October 18, 2023

My name is Diane Berge and my husband and I own property in Granite Creek at 1061 FS Rd 4517. I am strongly opposed to the proposed Development titled Fowler Creek Guest Ranch, CU-23-00003. While I have many comments regarding the detrimental effects this project will have on the Community and the environment, the following comments are related to estimated Vehicles, and Water & Sewer needs and their related impacts from the project.

SEWAGE MANAGMENT SITE PLAN MAP - FOWLER CREEK GUEST RANCH

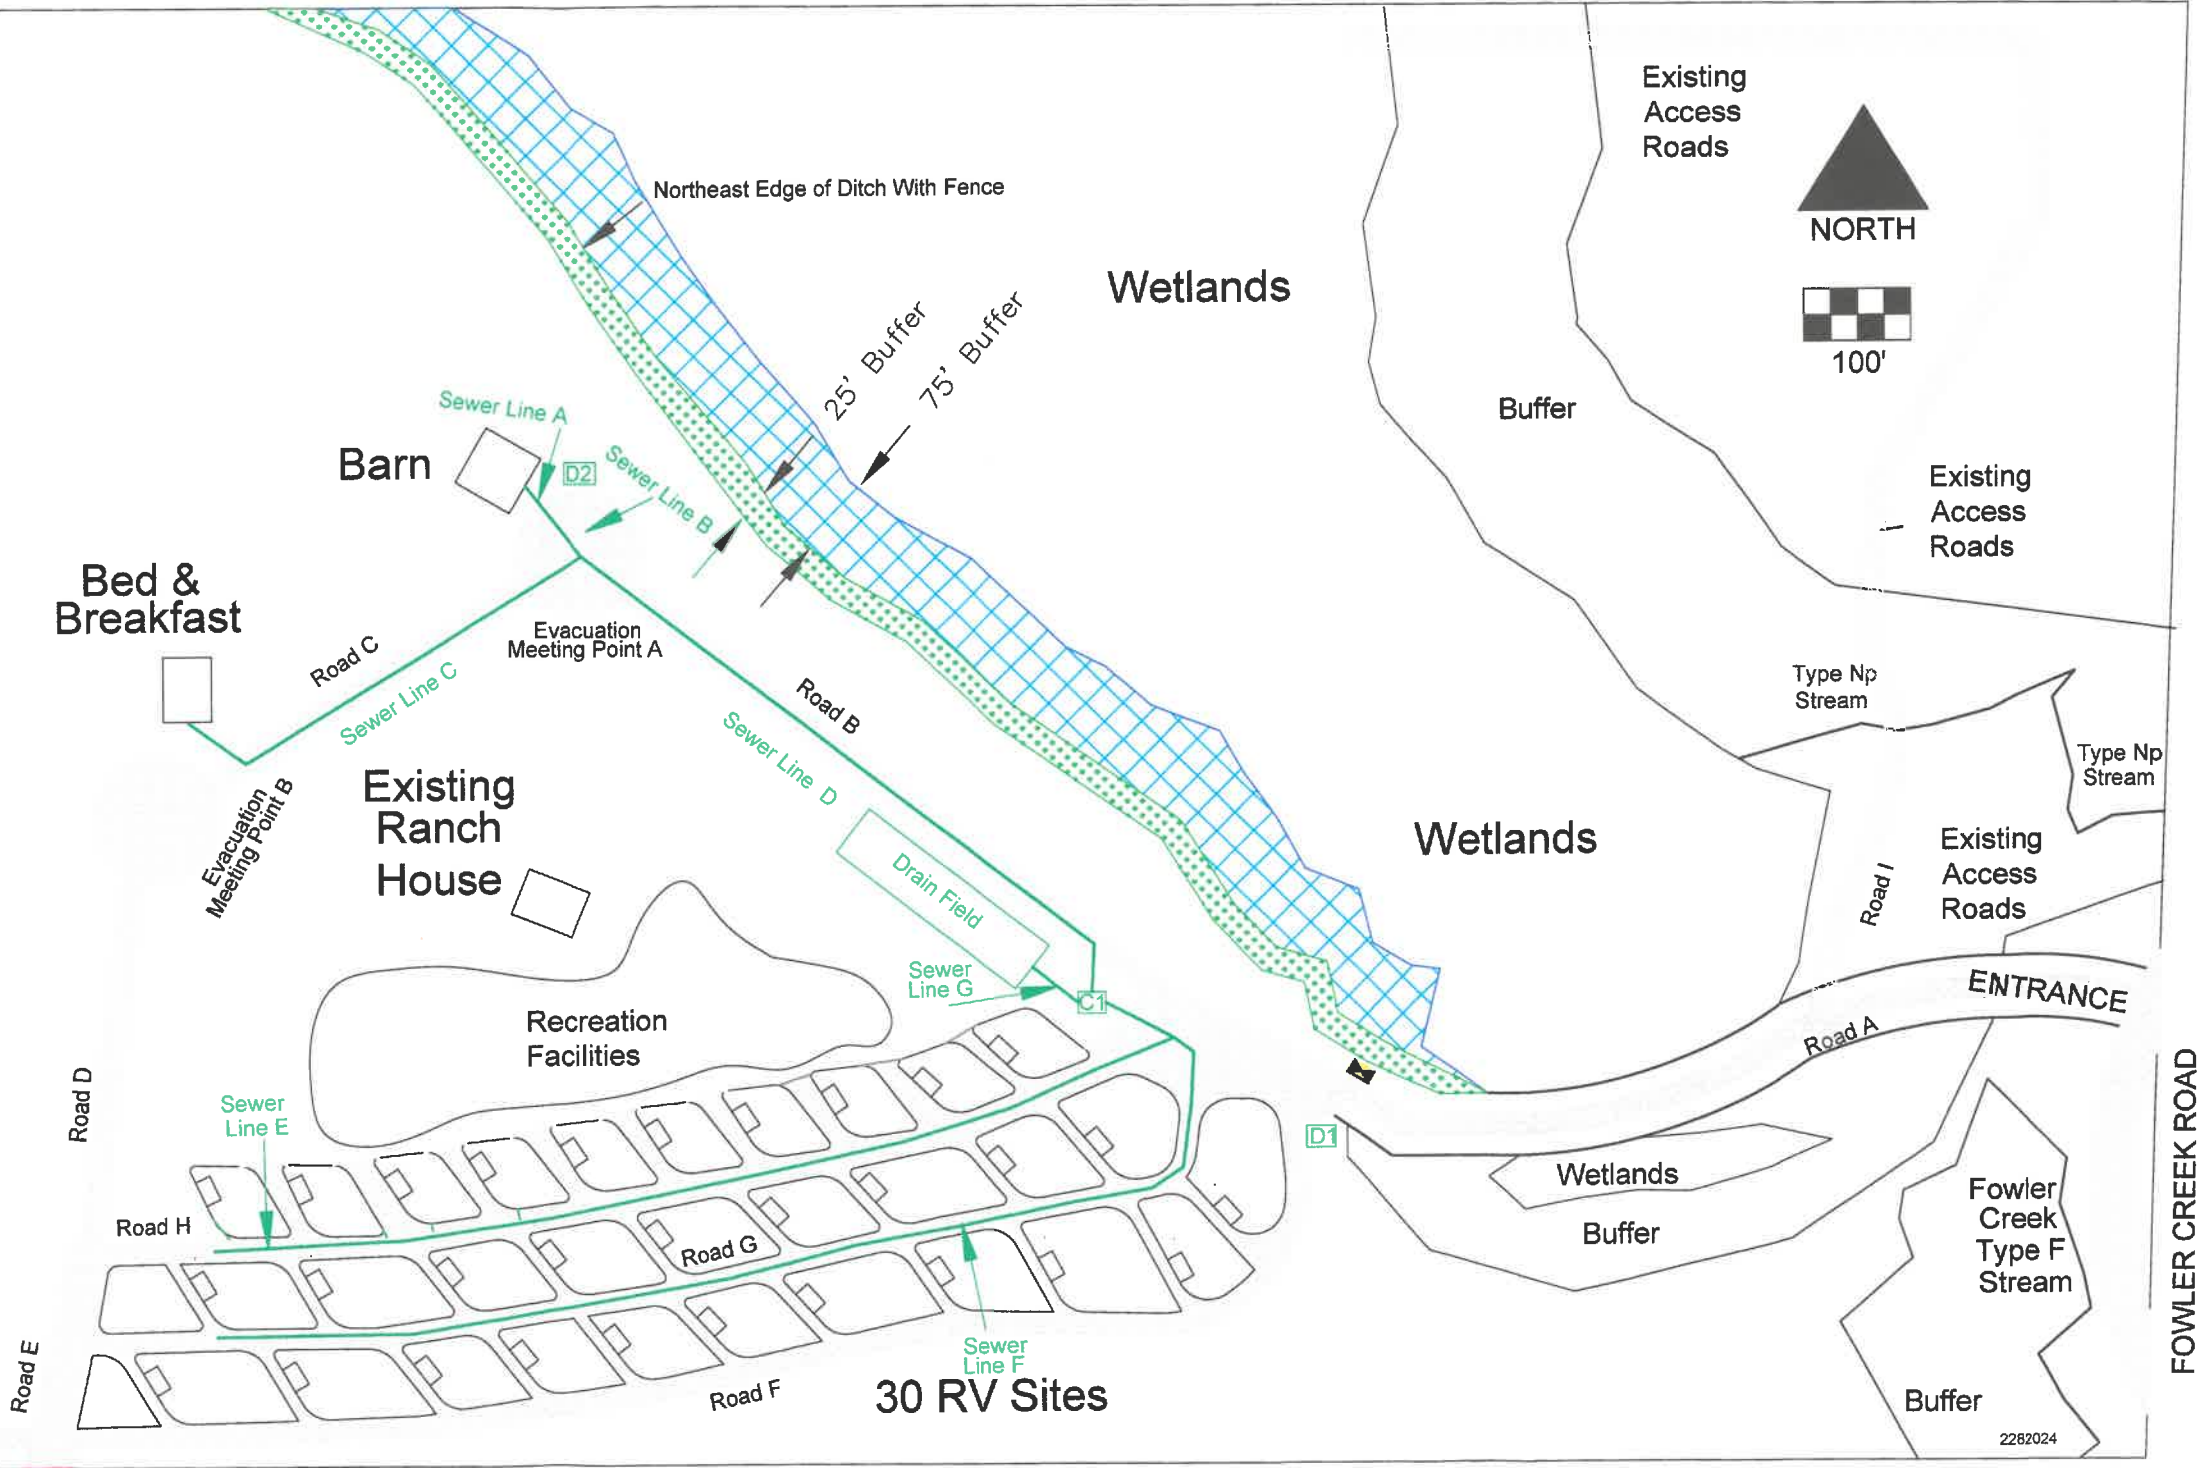
As noted in the attached estimate I provided, my estimated volume of sewage is much higher at 27,200 gpd than the 6620 gpd they have estimated. Their plan should be reviewed with this higher volume in mind. Larger drain fields, storage tanks etc. would be needed to handle this much sewage.
